30 June 2021

**RE: PROPOSED MIXED USE DEVELOPMENT – EDEN STREET & PRINCESS HIGHWAY, ARNCLIFFE
BCA COMPLIANCE STATEMENT FOR DA SUBMISSION**

This BCA Compliance Statement for DA is submitted to the Department of Planning, Industry and Environment (DPIE) in support of a State Significant Development Application (SSDA-11429726) for the development of land identified at 26-42 Eden Street and 161-179 Princes Highway, Arncliffe (the site) for the purposes of a mixed-use precinct with open space, retail, and residential uses, comprising social and market housing as part of the NSW Land and Housing Corporation (LAHC)'s 'Communities Plus' program.

Figure 24 South Precinct lower ground level floor plan, with retail parking

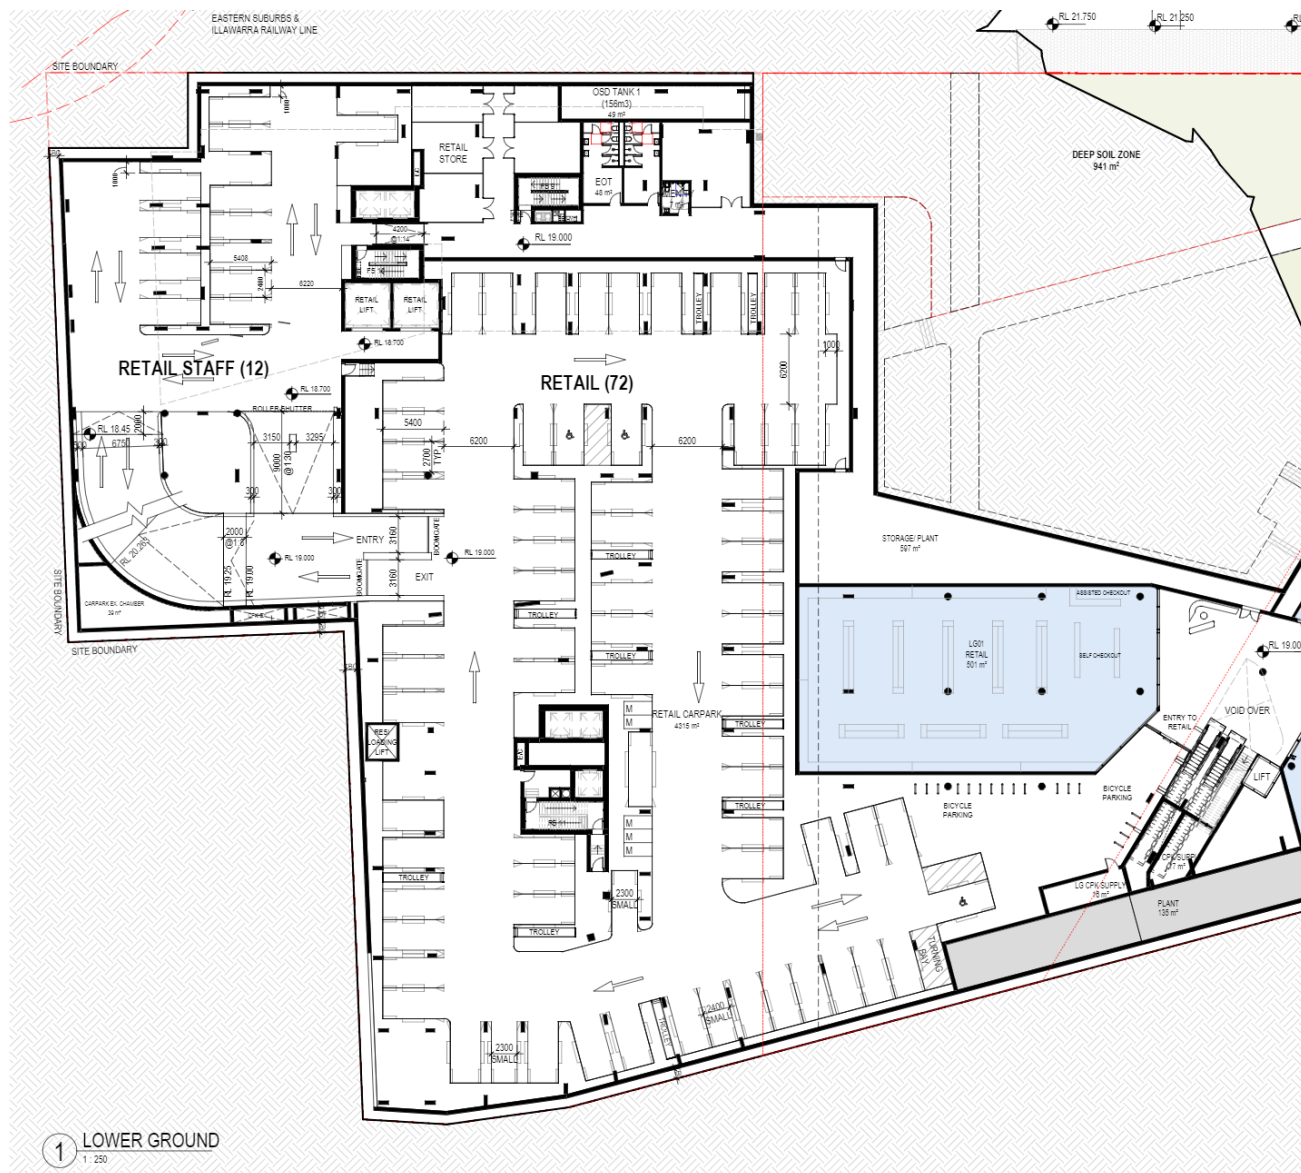
As shown in Figure 4, there are openings in adjoining fire compartments between the class 2 townhouses and the adjoining retail compartment, and the mini chamber substation and loading dock. As such, protection of external wall and associated openings in different fire compartments is required in accordance with C3.4.
